# **Marge Schmuckal - Re: Meeting with Gregory Gayre 12 Tarbell road/deck and addition**

RE: Illegal deck at 12 Tarbell Street – R-3 zone – 332 E038

Re: 12 Tarbell Street – 332 E038 – R-3 – 16' x 20' single story addition – permit #09-1235

<b>PLOT PLAN</b>	
SCALE: 1/4" = 1'	APPROVED BY:
DATE: OCT 29 09	DRAWN BY: JUDY ALLEN/AS
BEDROOM ADDITION 16X20	
OWNER: GREGORY GAY 12 TARBELL ST	
PARL AND 318	
DRAWING NUMBER	I

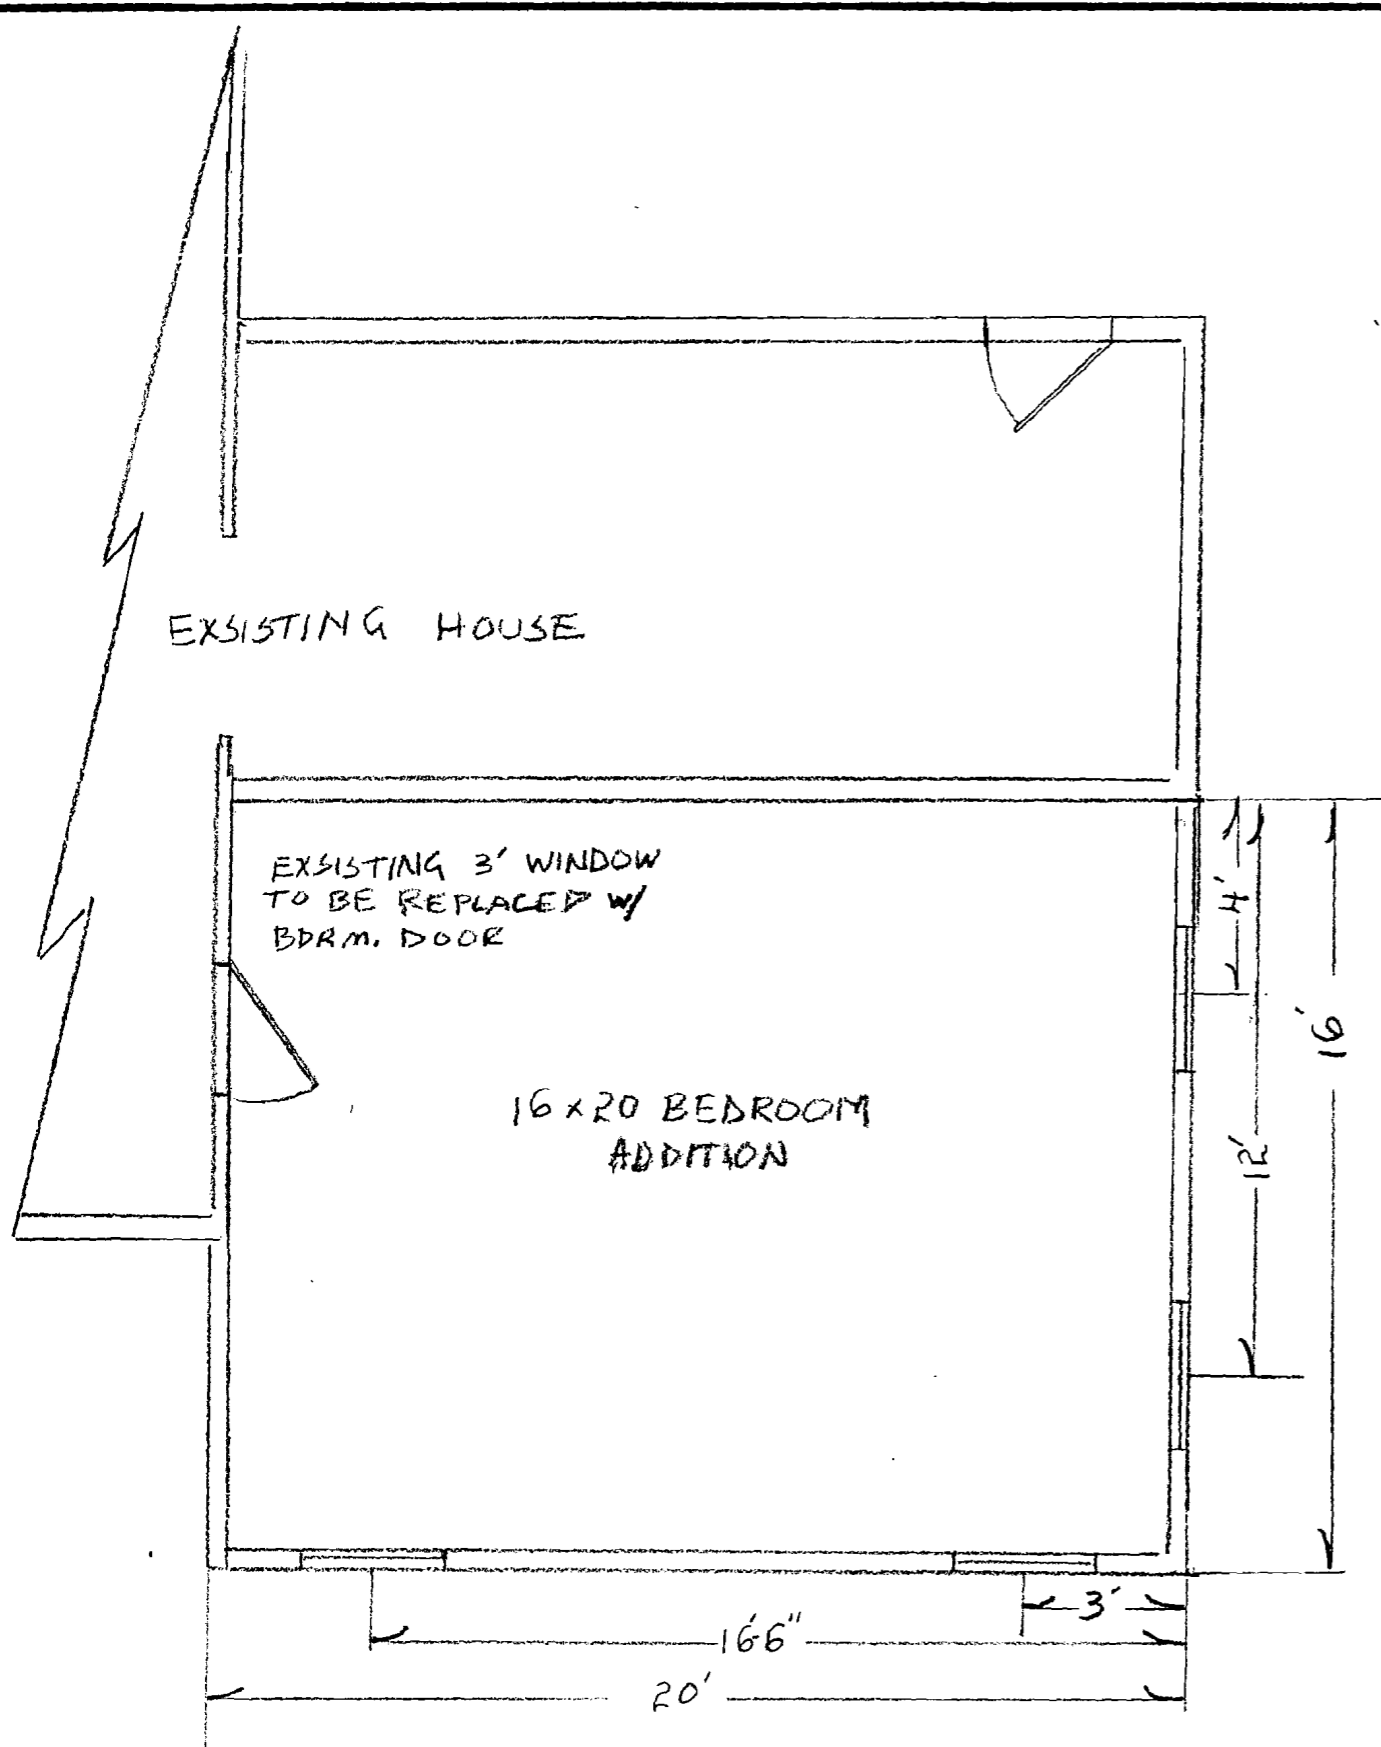
The required rear setback is 25' for the R-3 zone – the plot plan shows the deck at 11' to the rear property line.

12 Tarbell Street is located in the R-3 residential zone. The required rear setback in the zone is twenty-five feet [Section 14-90(d)(2)]. The plot plan shows the rear setback to the proposed addition as twenty feet. Since it does not meet the required setback, the permit is denied.

In reviewing the permit application, it came to my attention that the existing deck on the rear of the house has never been permitted. We have no record in our system for a deck having been built. When we cannot find a permit for a structure, we default to the pre-1957 assessor's record. The pre-1957 assessor's record shows a six by twenty foot deck on the left rear side, but not the deck that exists now. Since the existing deck was not built before 1957 and there is no record of it being permitted, it is illegal.

The property must be brought into compliance. Since the setback for the existing deck does not meet the required twenty-five foot rear setback, it cannot be permitted after the fact. Since it cannot be permitted, it must be removed. You have thirty days from the date of this letter to remove the deck.

I received an application (#09-1235) on November 2, 2009 to add an addition at 12 Tarbell Street. The plot plan showed that the addition was not meeting the rear setback. The plot plan also showed an existing rear deck that was not meeting the rear setback. I found no record of the deck being permitted. I called the contractor on November 6, 2008 and told him.
